From: [Weston Parish Council](#)
To: [Great North Road Solar](#)
Subject: Weston Parish Council comments Solar Farm in Newark & Sherwood Notts
Date: 08 December 2023 08:10:45

Comments from individual Councillors (1 abstained):
"Environmental impact assessment scoping - Great North Road Solar Park

Flood Zones 2 & 3 Figure 7.1

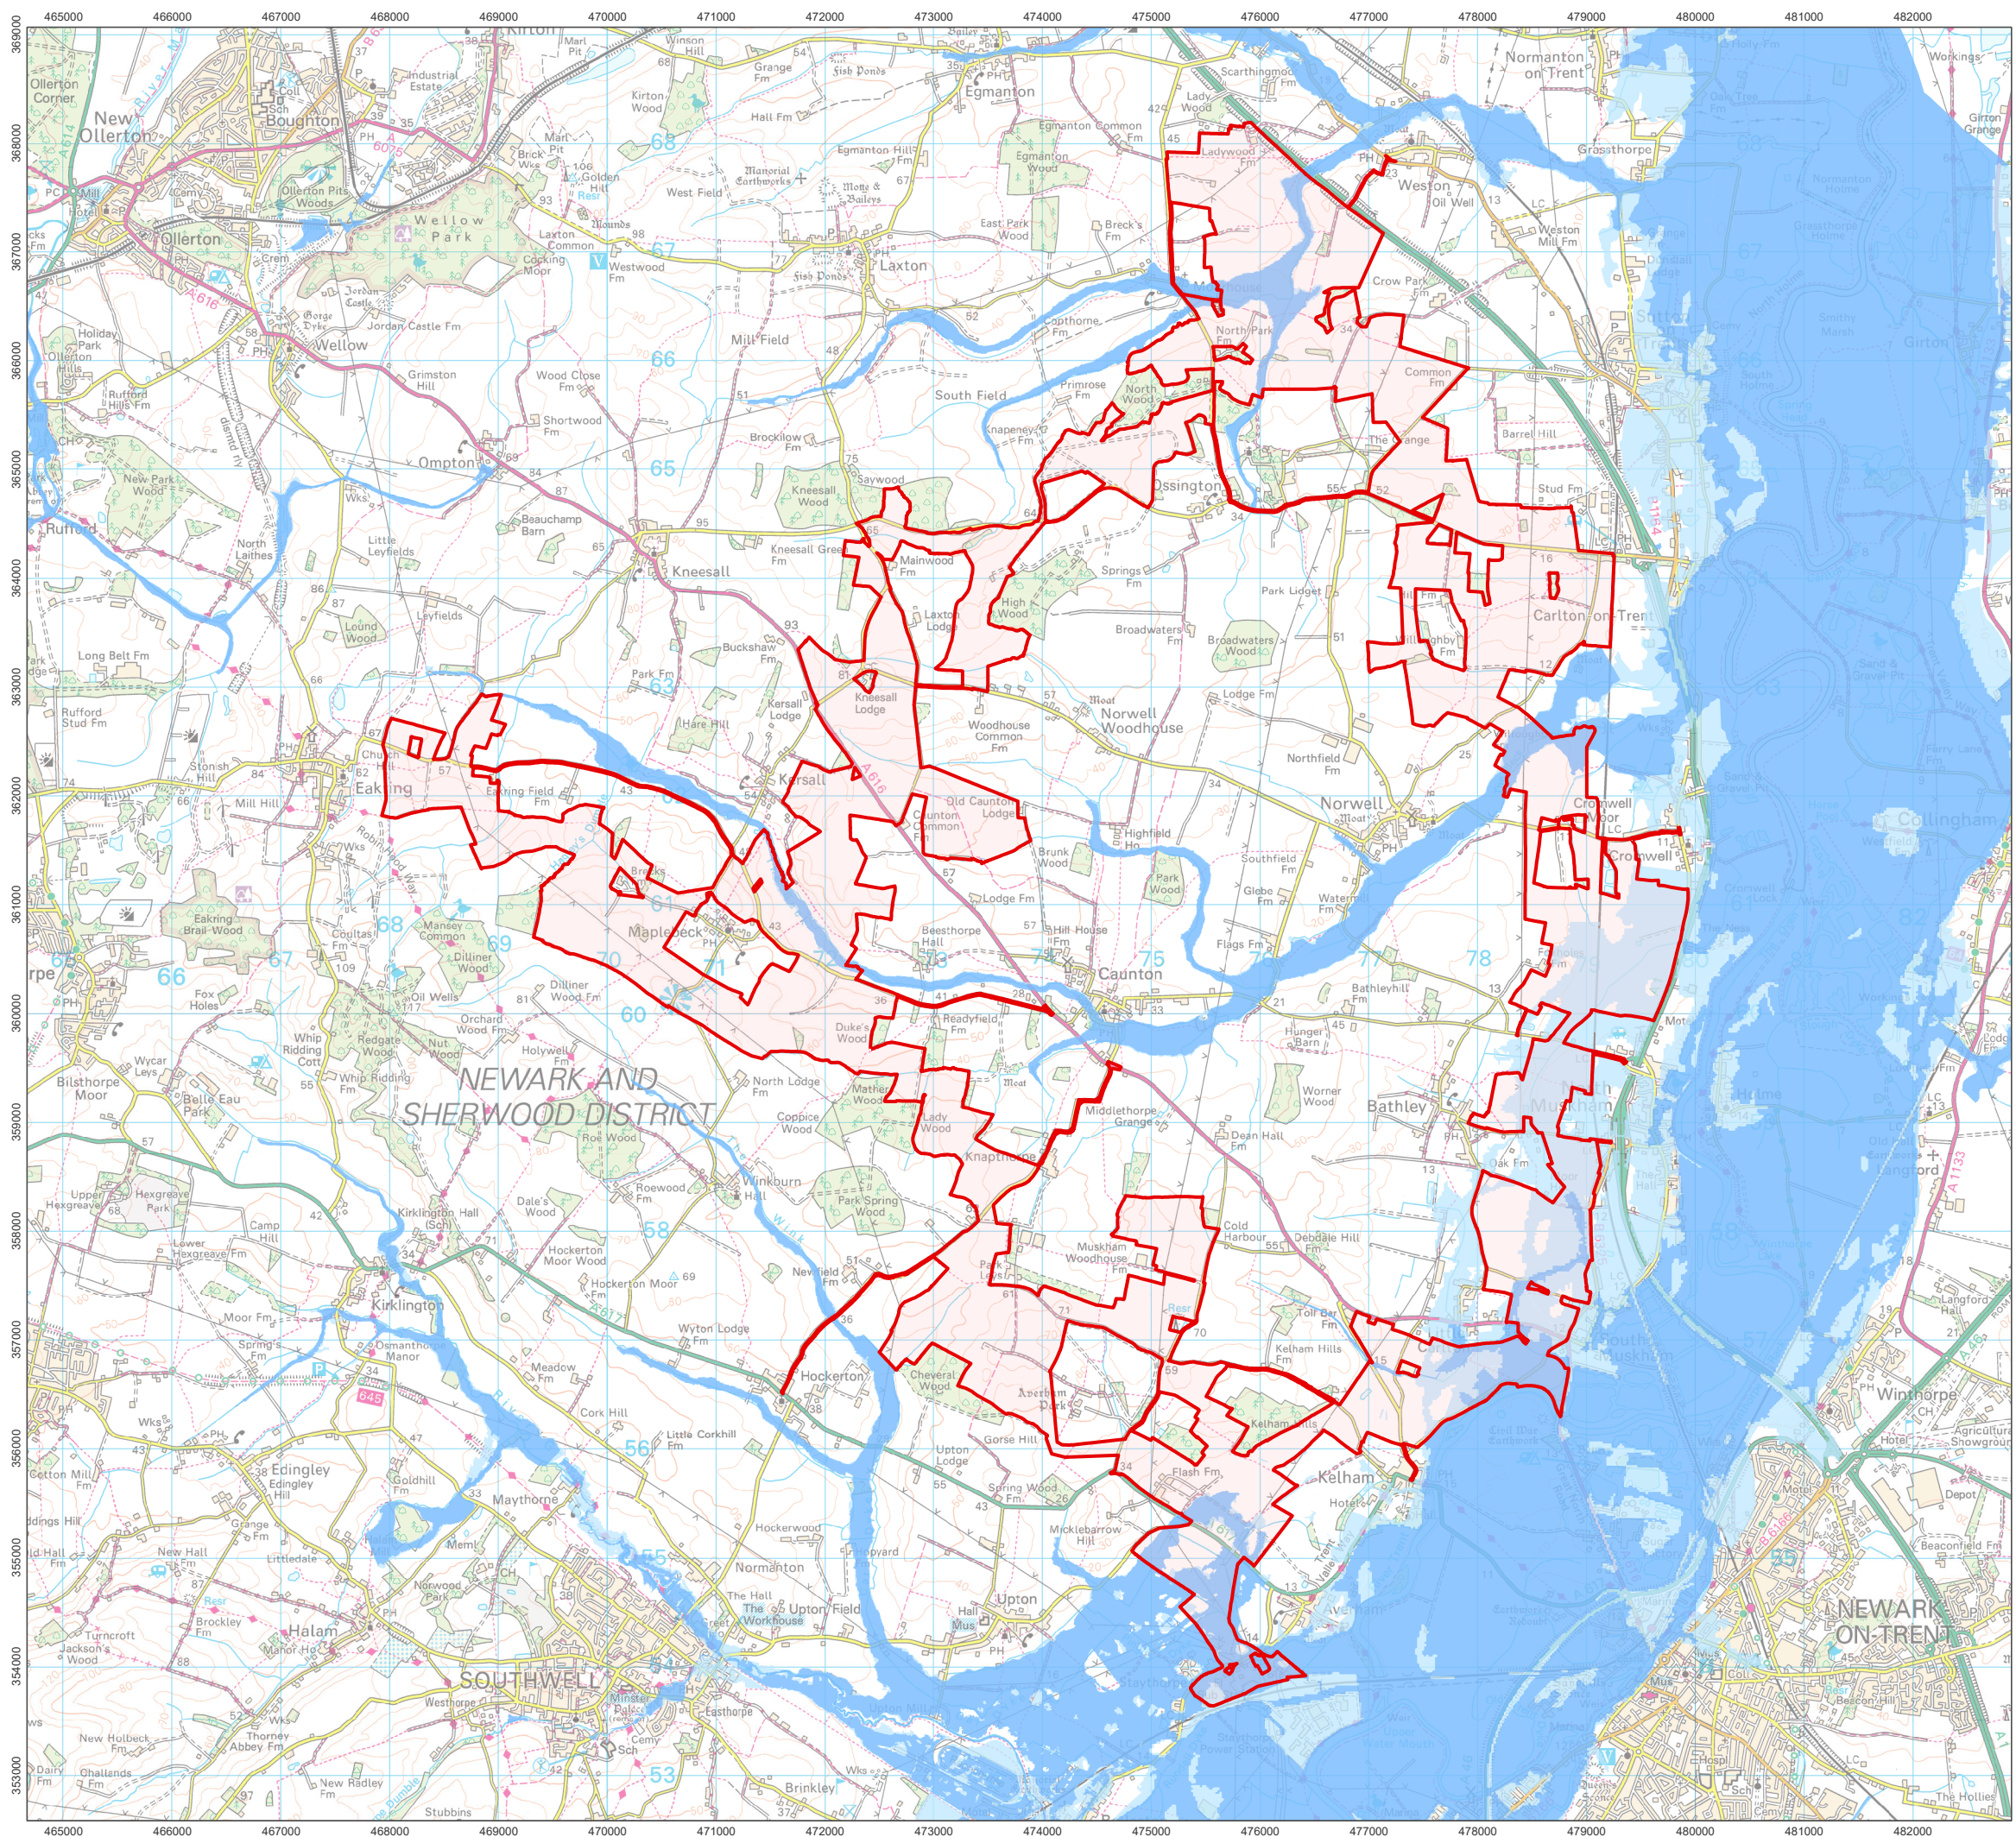
Parts of Moorhouse beck are not managed properly and regularly floods on part of the land

in the proposed scheme around Weston"

Public Rights of Way
Figure 10.1 - Overview

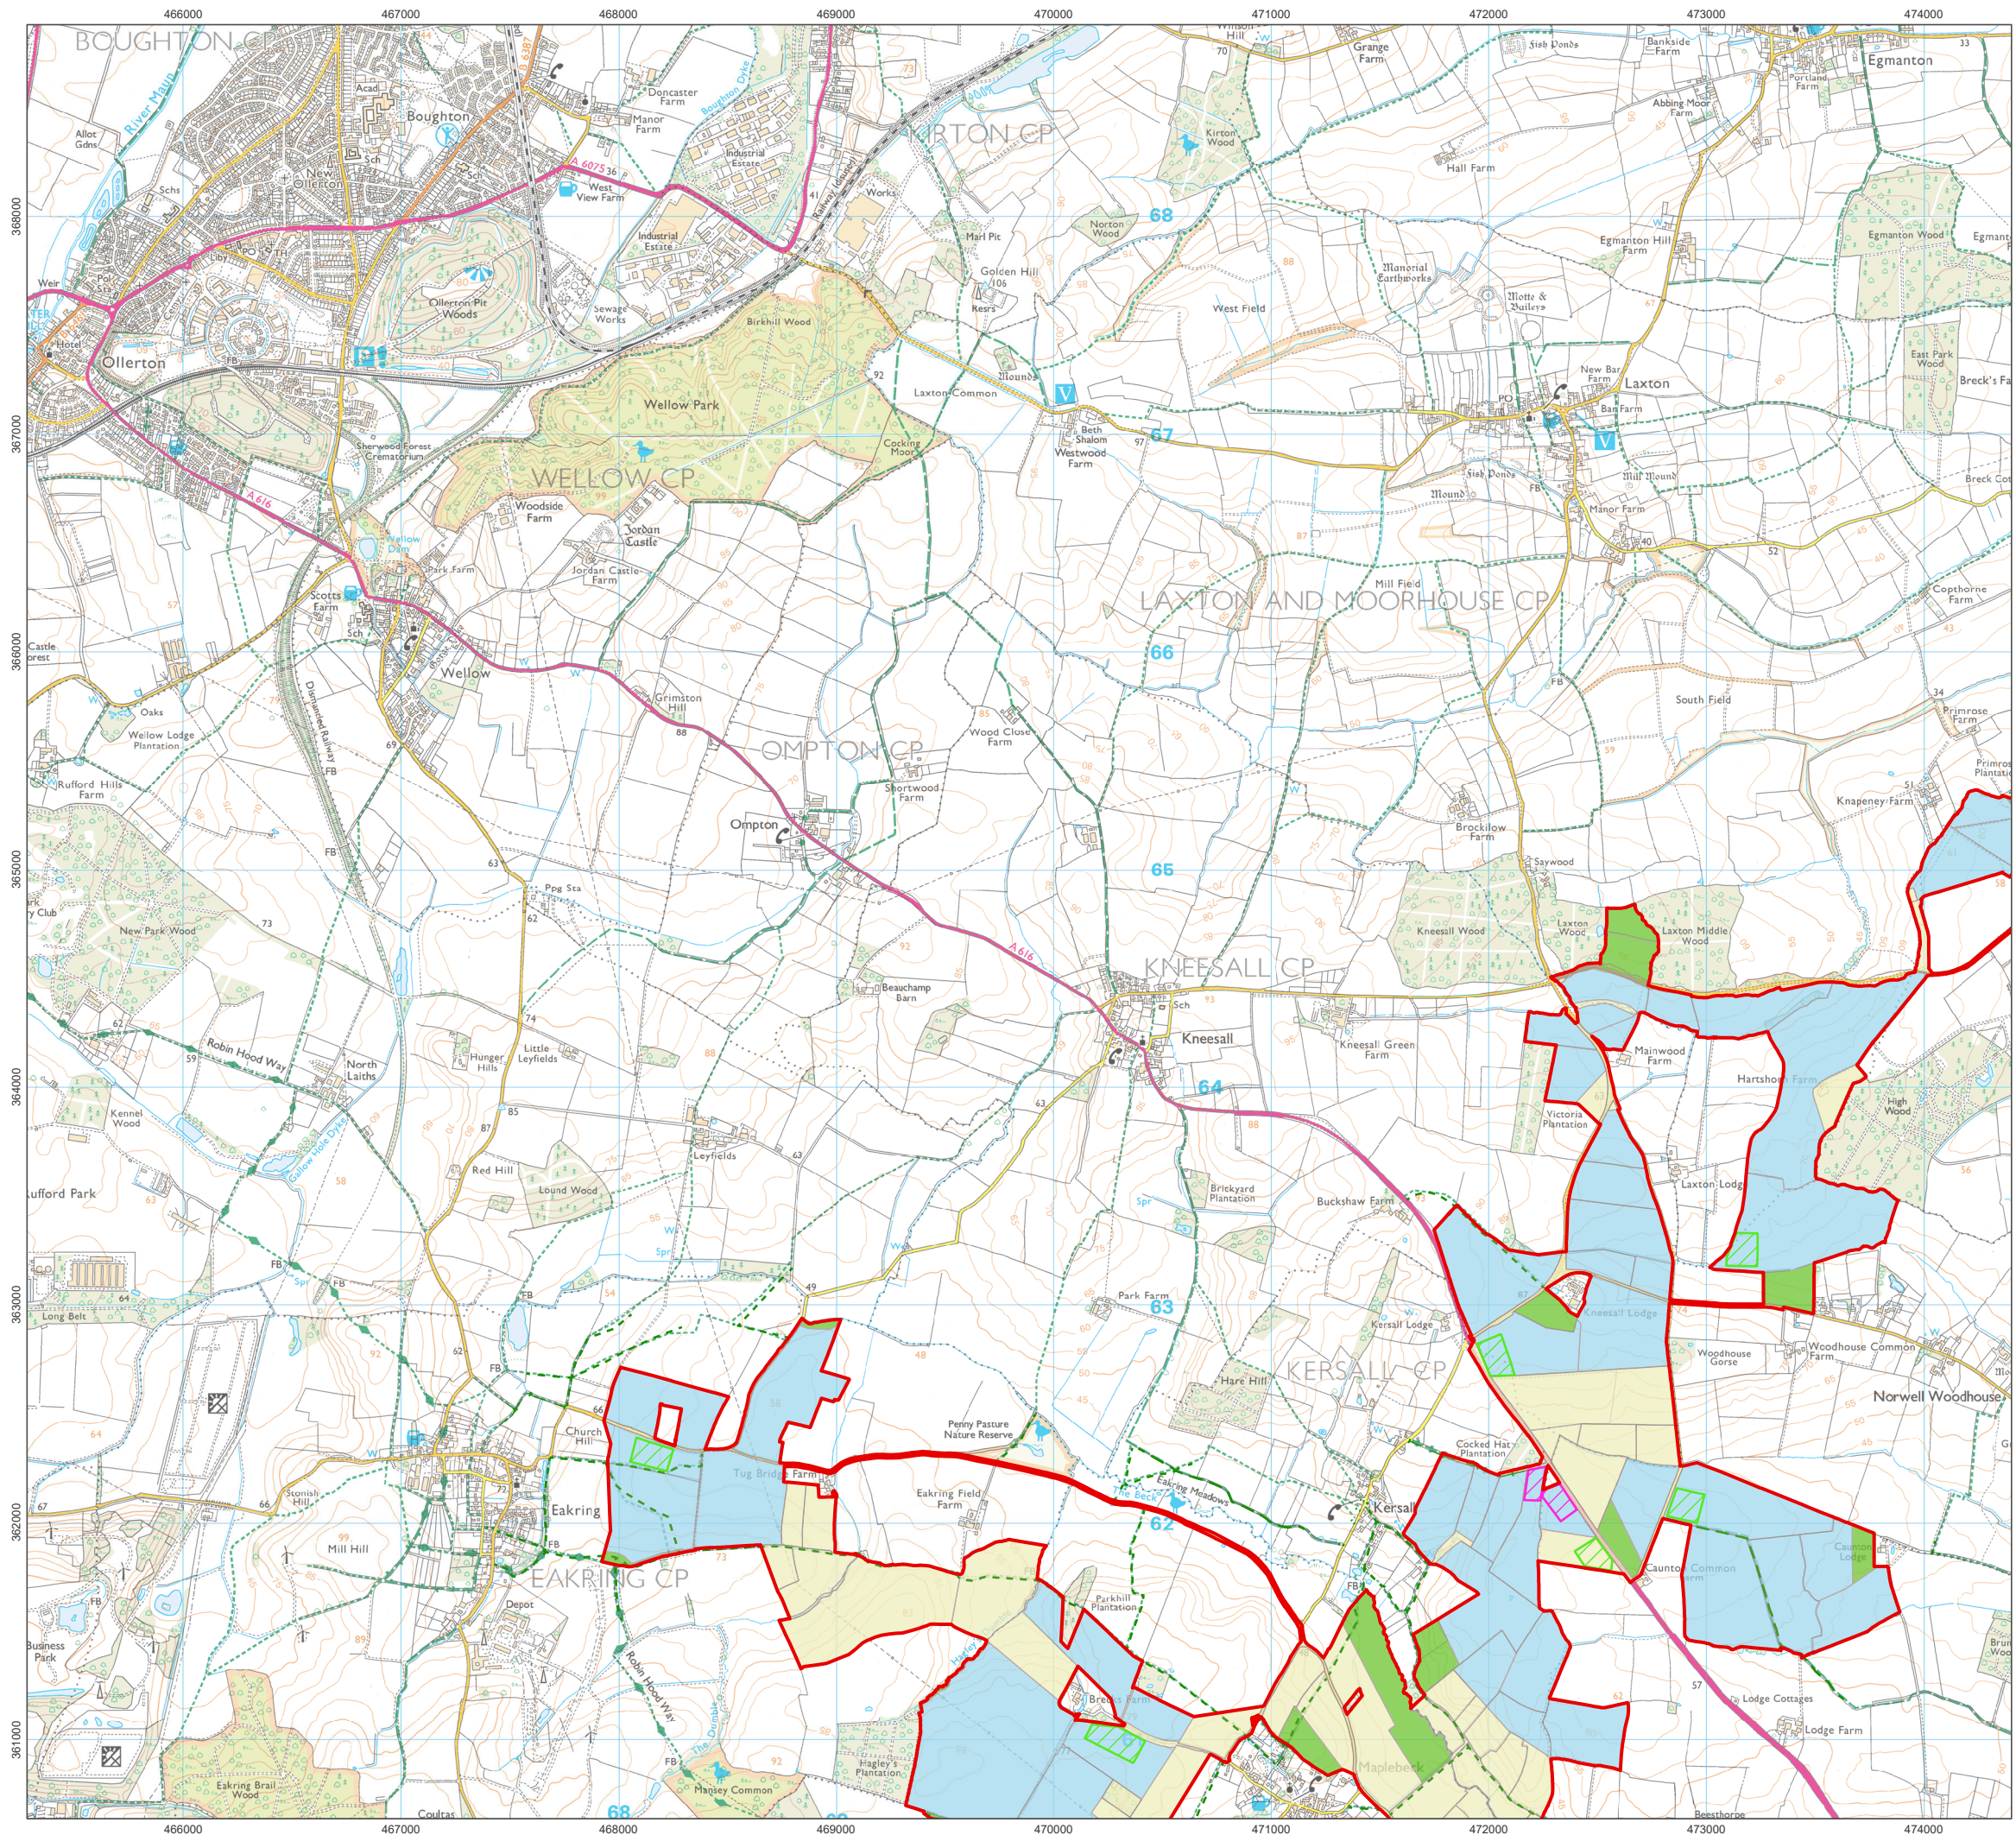
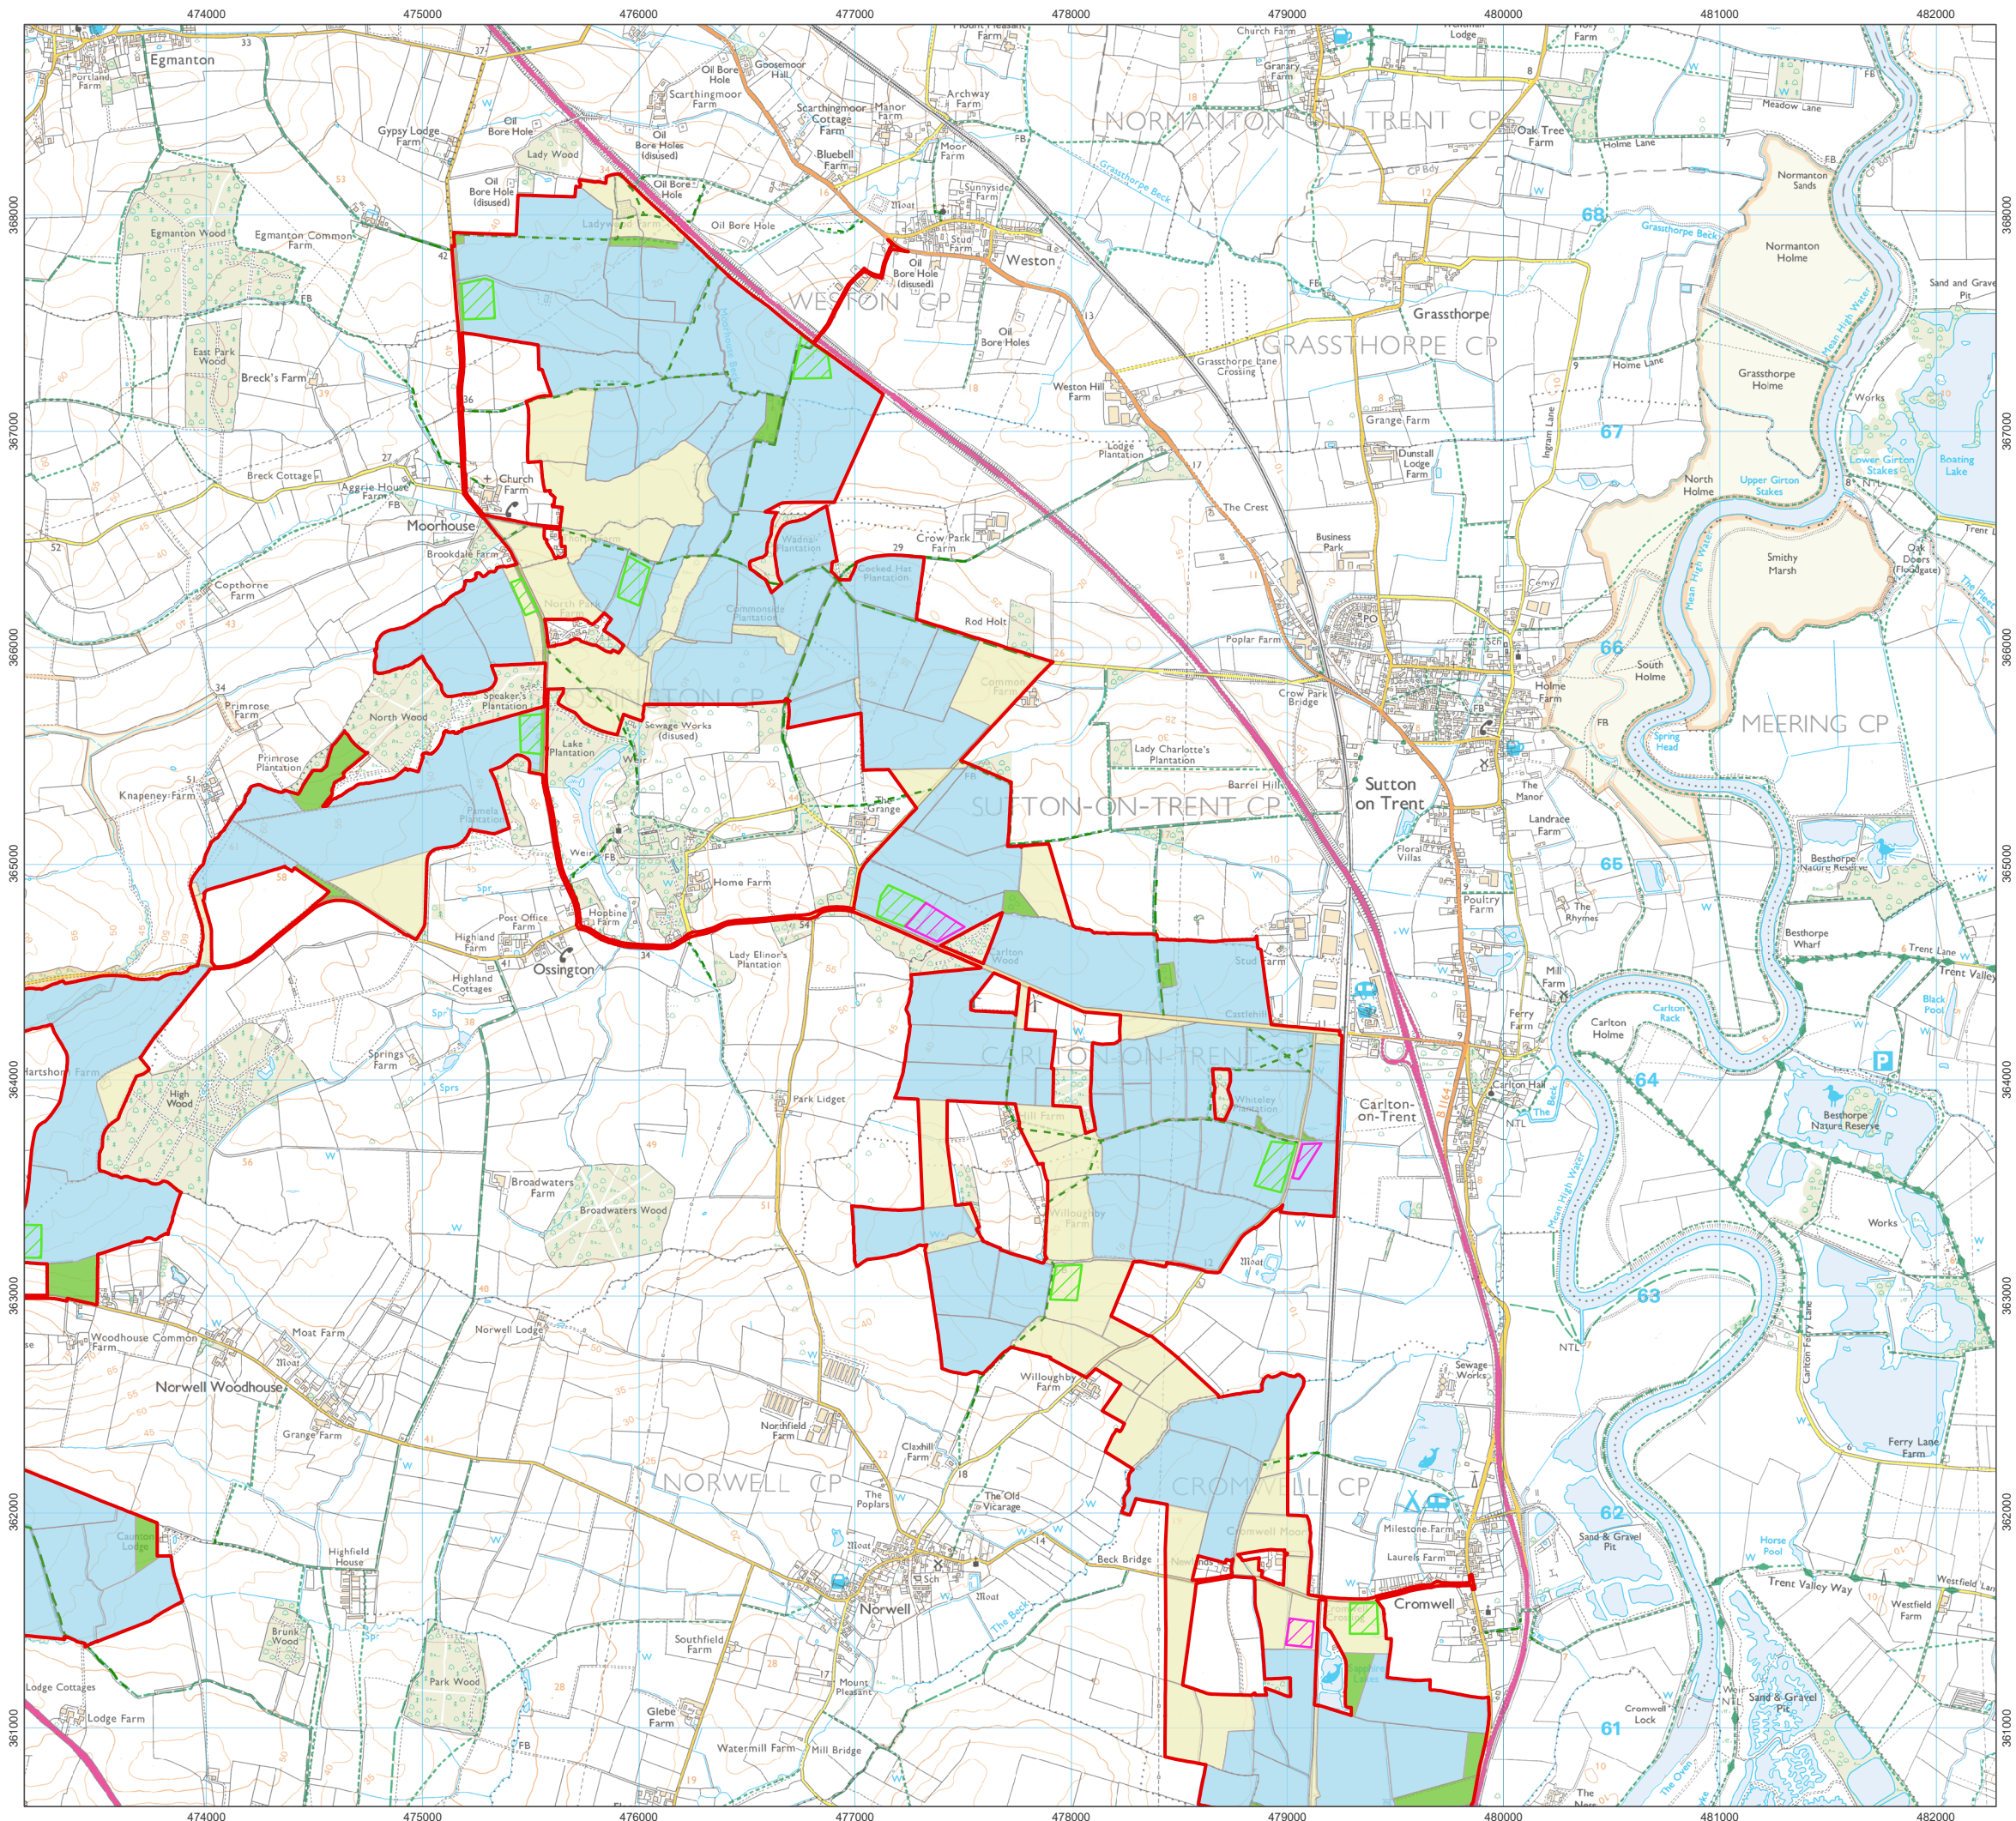
Disruption to walkers and horse riders to footpaths and bridleways during construction phase. Nine footpaths and one bridleway will be affected.
